# RETREAT AT TIMBERRIDGE FILING NO. 4

## CONSTRUCTION DRAWINGS

FEBRUARY 2024

EPC STORMWATER REVIEW COMMENTS  
IN ORANGE BOXES WITH BLACK TEXT

RETREAT AT TIMBERRIDGE FILING NO. 4 CONSTRUCTION DRAWINGS TITLE SHEET			
DESIGNED BY	PRA	SCALE	DATE 2-29-24
DRAWN BY	PRA	(H) 1" = N/A	SHEET 1 OF 14
CHECKED BY		(V) 1" = N/A	JOB NO. 1185.31

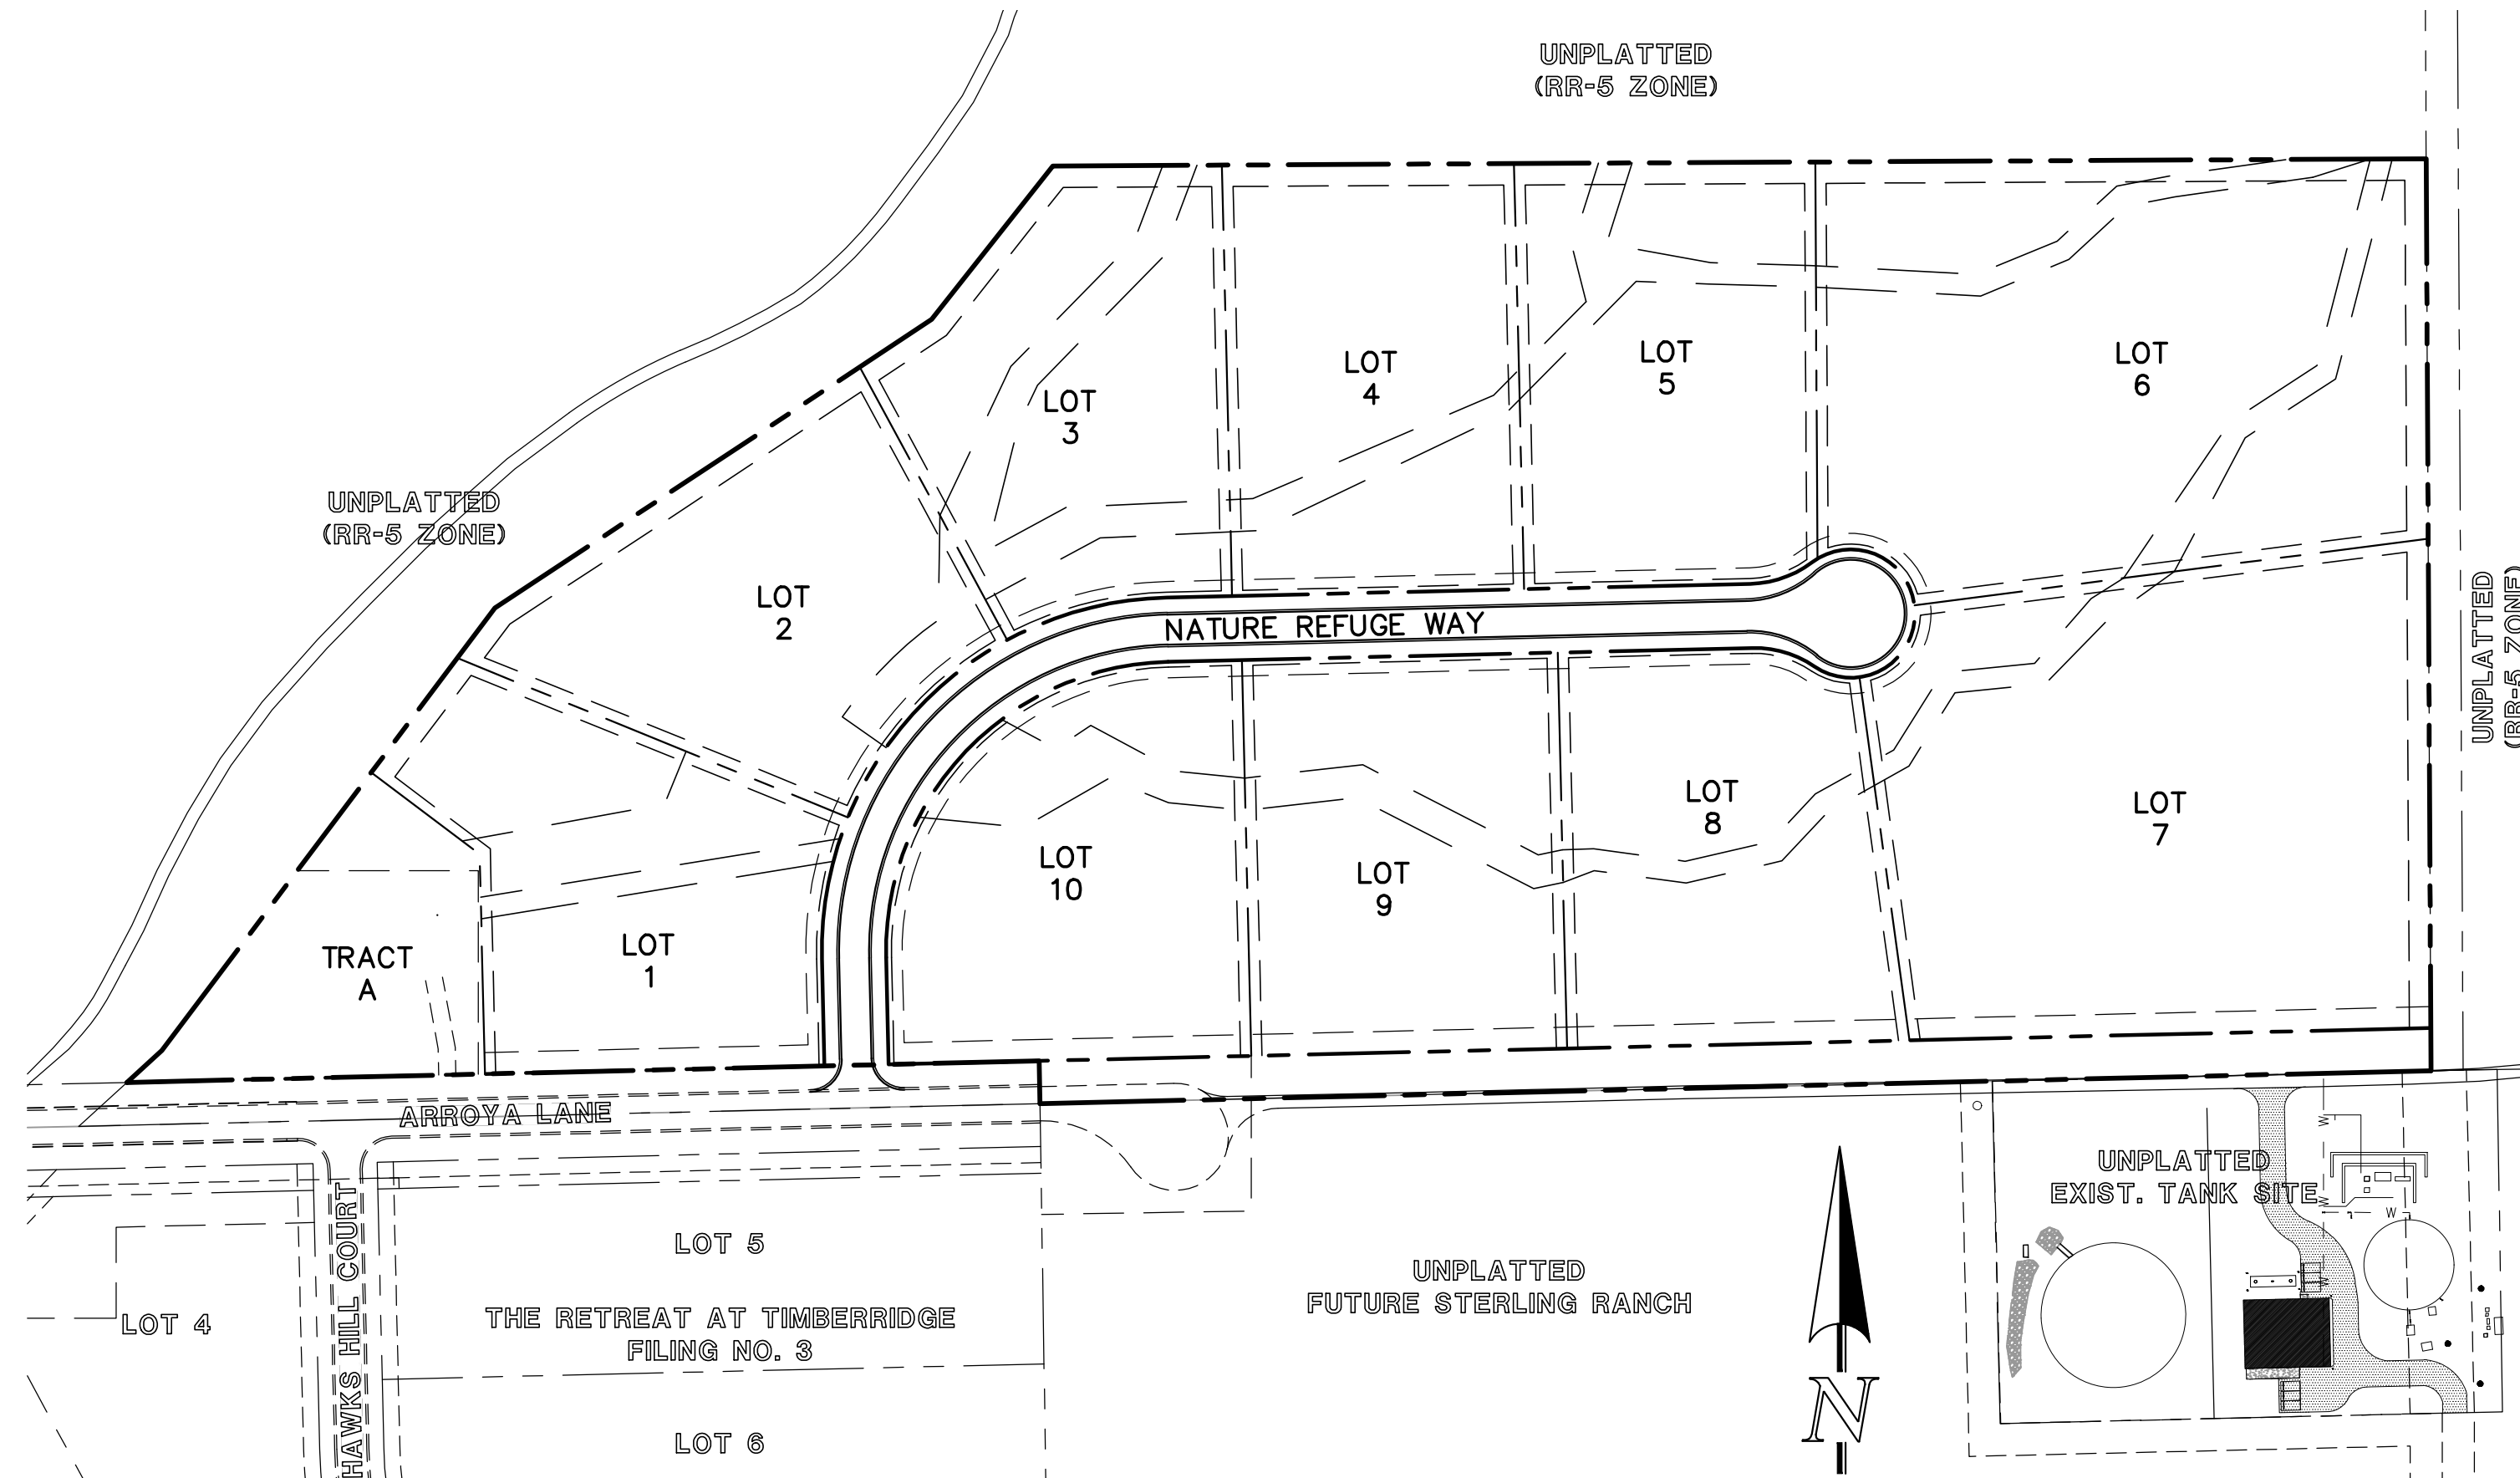
Delete or  
replace all  
highlighted  
PCD references  
with EPC or  
DPW.

"of the grading and erosion control plan and all of the requirements specified in these detailed plans and specifications." Match the GEC Checklist signature

Revised  
all

Revised per std. CDs  
owners signature.
